From: Rebecca Bowers
Sent: 20 April 2021 15:25
To: Planning
Subject: RE: 20 Hippings Way, Clitheroe 3/2021/0241 for comments asap
Categories: Yellow Category

From: Hardie, Simon <Simon.Hardie@lancashire.gov.uk>
Sent: 20 April 2021 13:41
To: Rebecca Bowers <Rebecca.Bowers@ribblevalley.gov.uk>
Subject: RE: 20 Hippings Way, Clitheroe 3/2021/0241 for comments asap

1 0 PROPOSED GROUND FLOOR
1 : 100

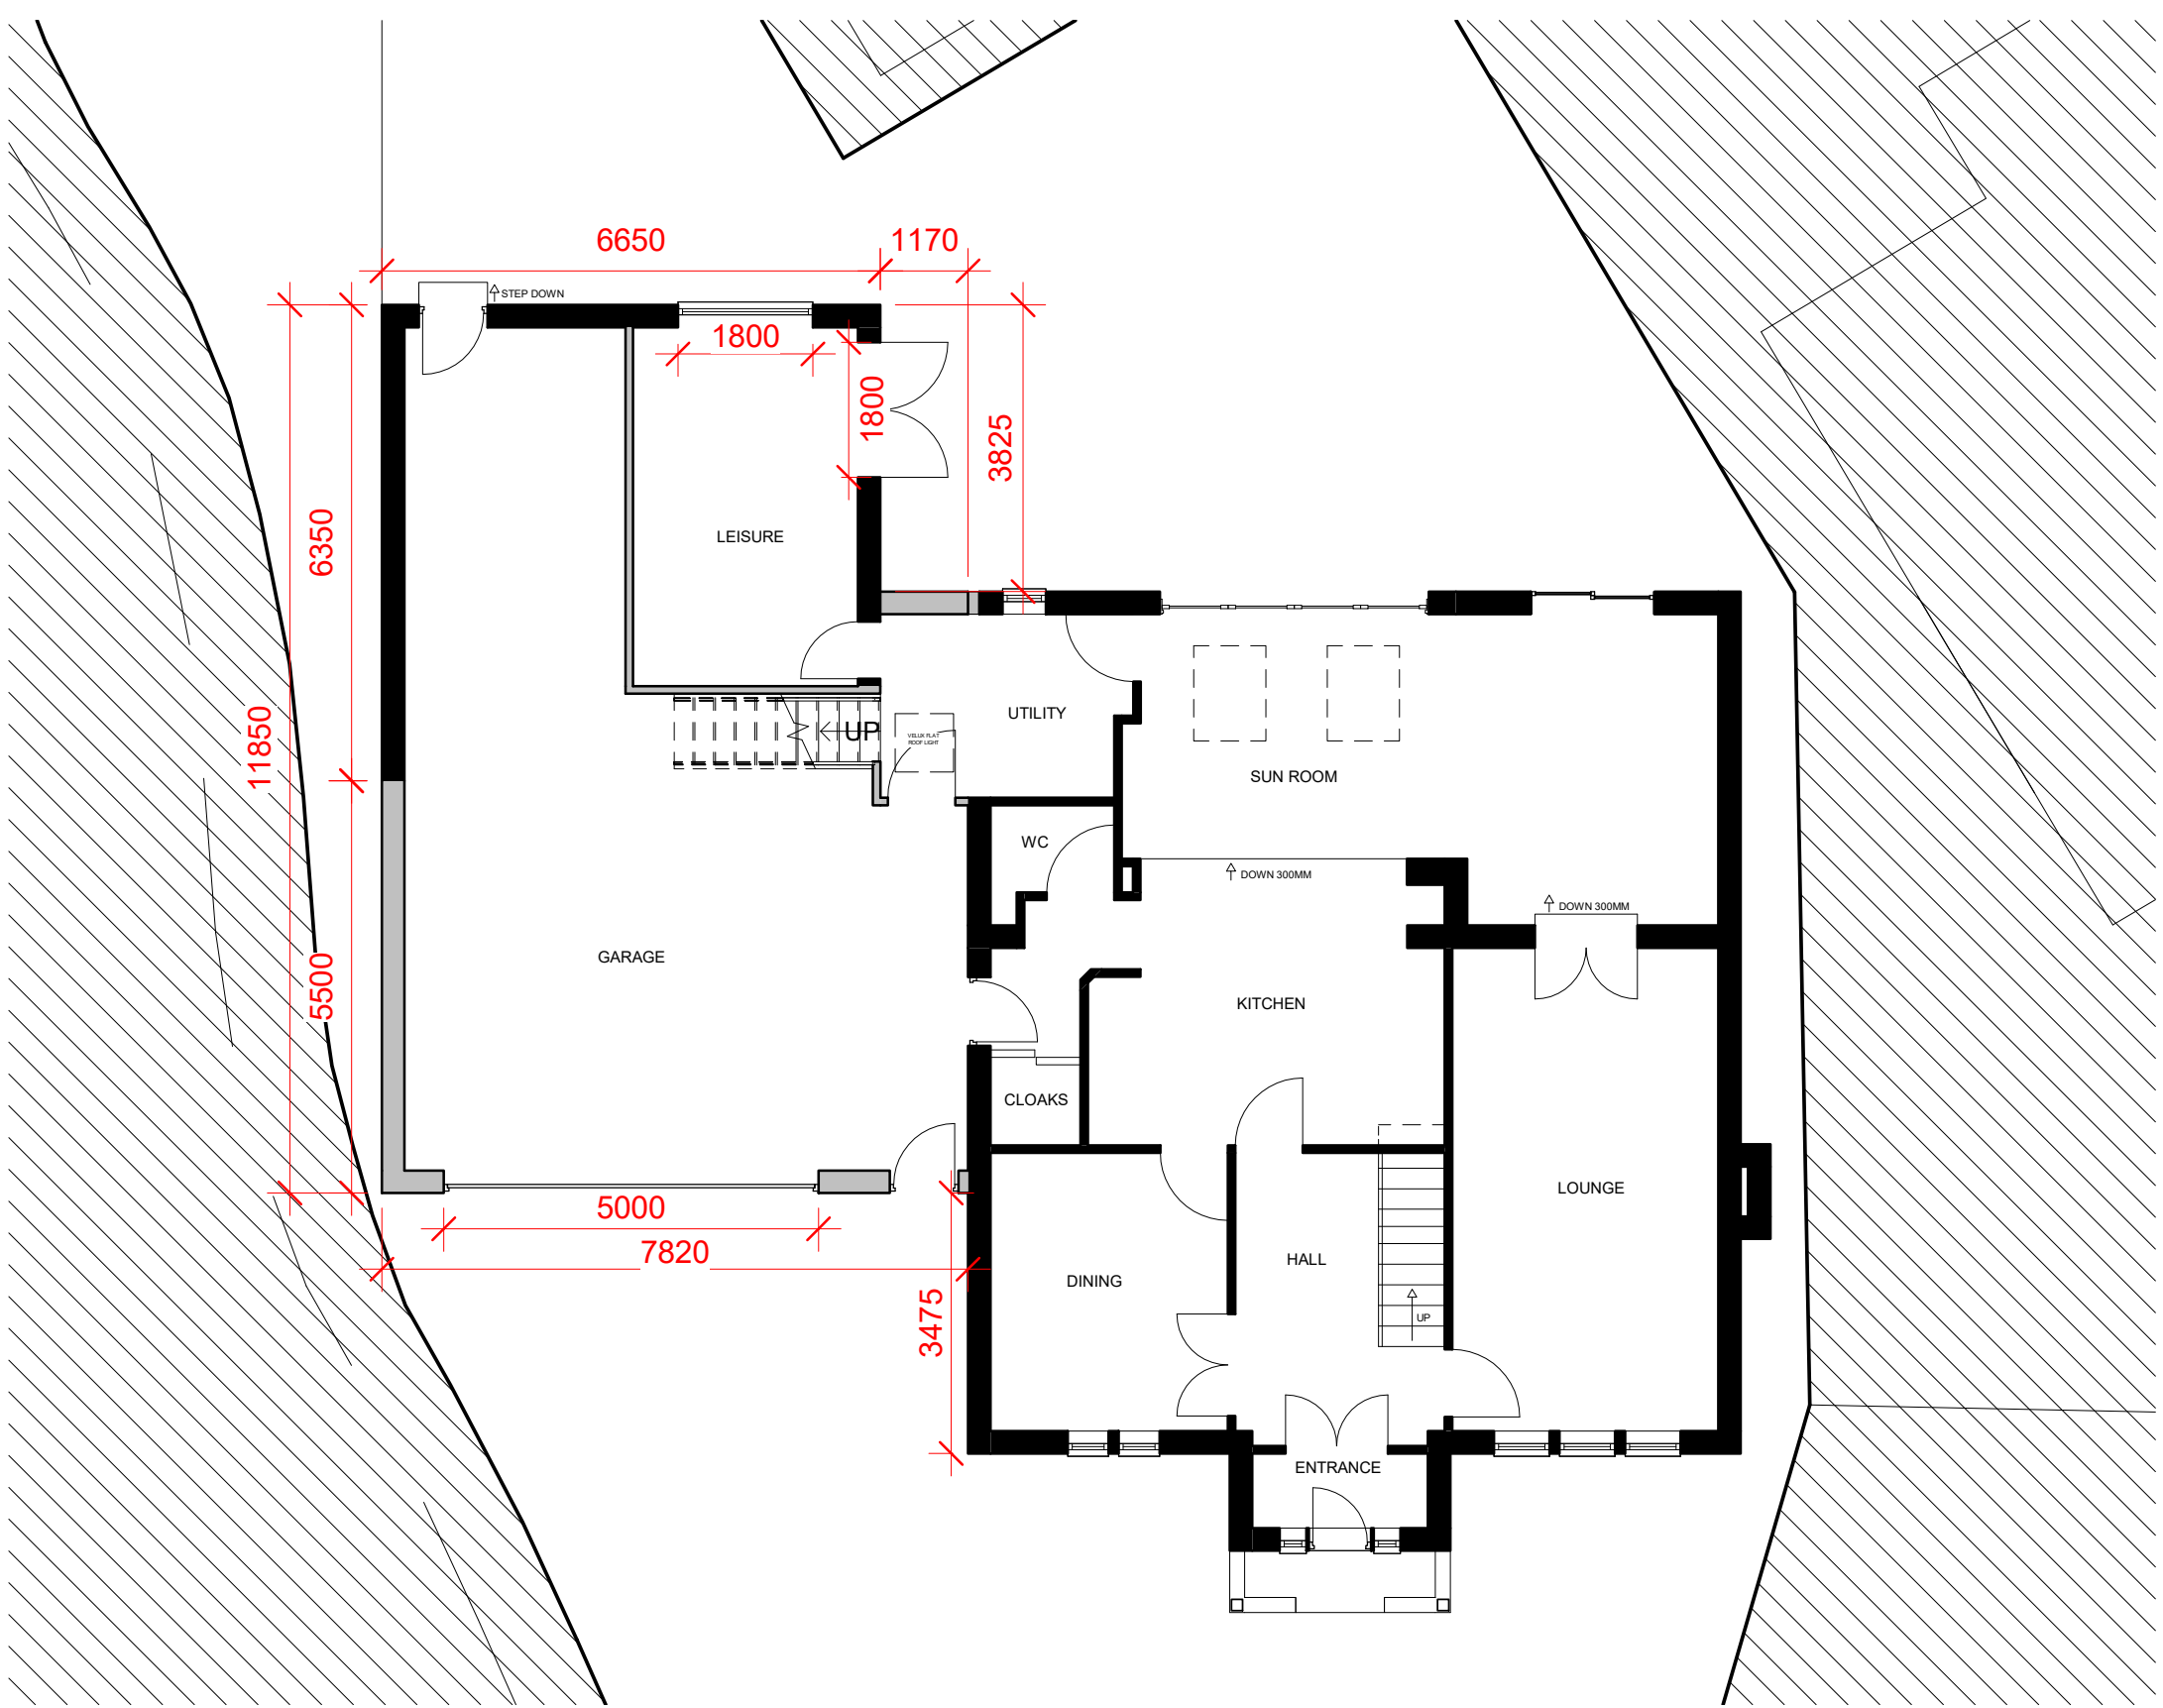
I would agree part of the garage is only 5.5m long, if a car is up to the base of the stairs it could then block the internal access to the utility room.

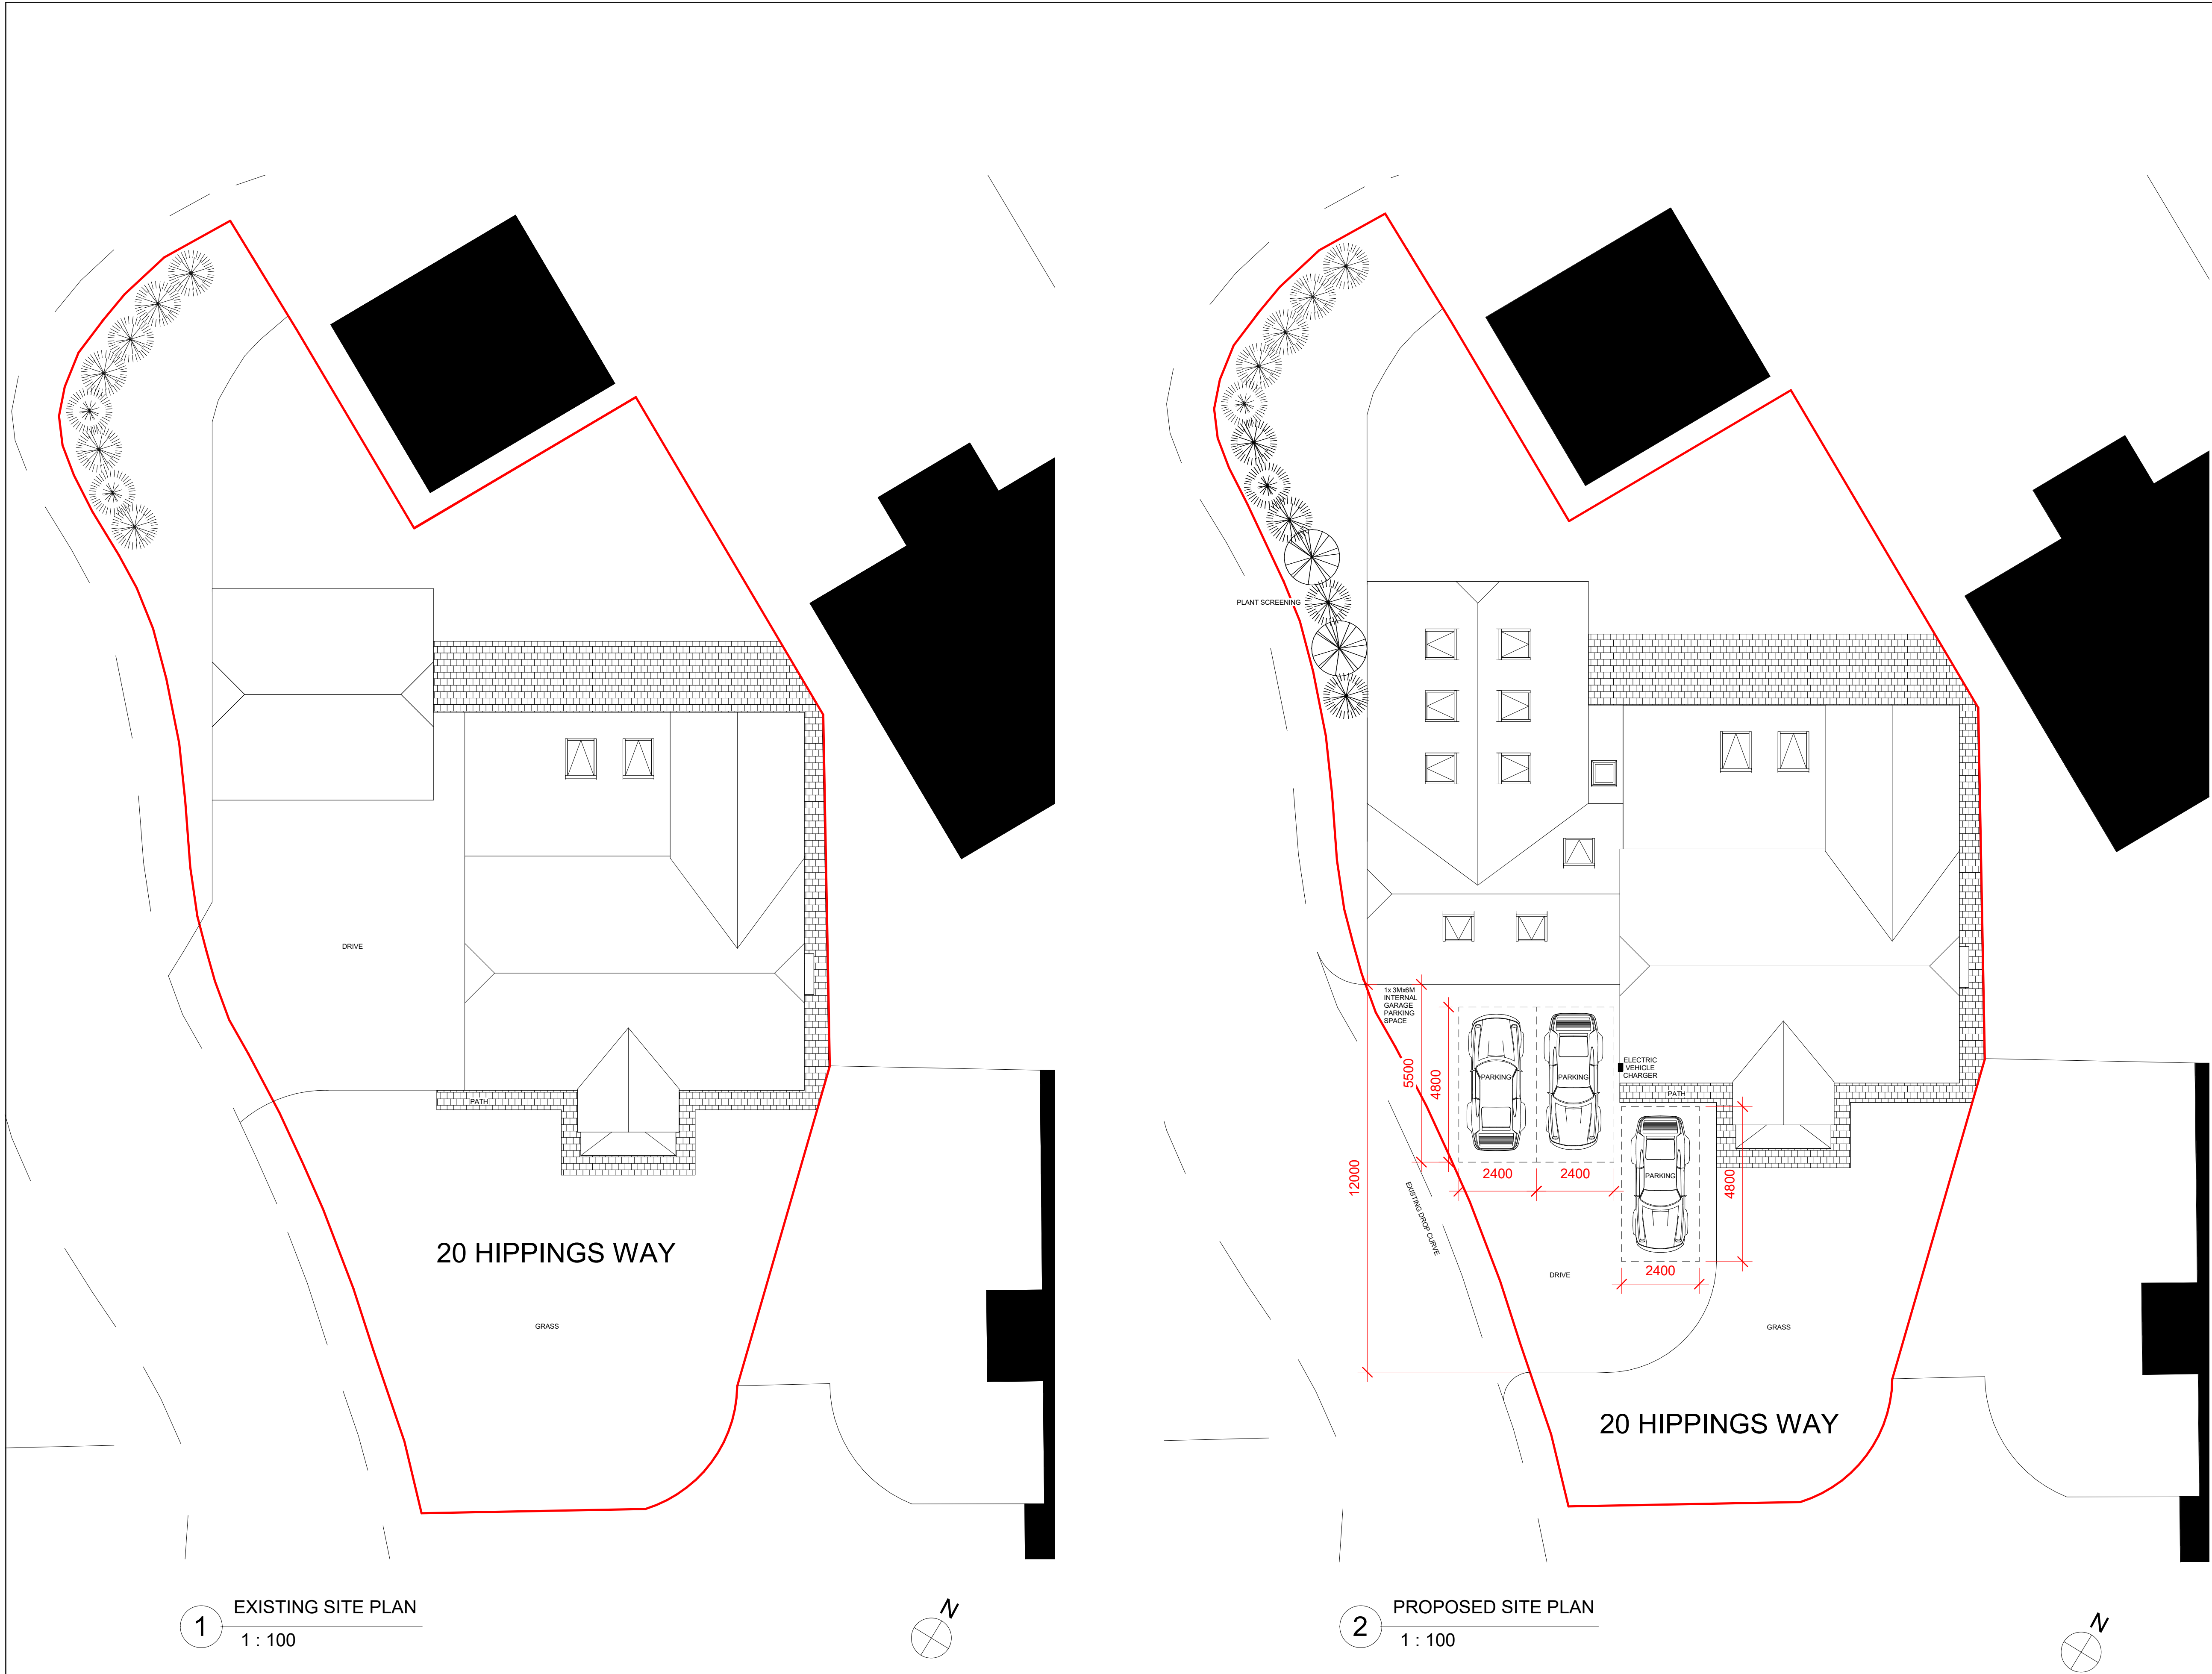
It has also not been demonstrated that the driveway has sufficient length to accommodate 2 parked vehicles.
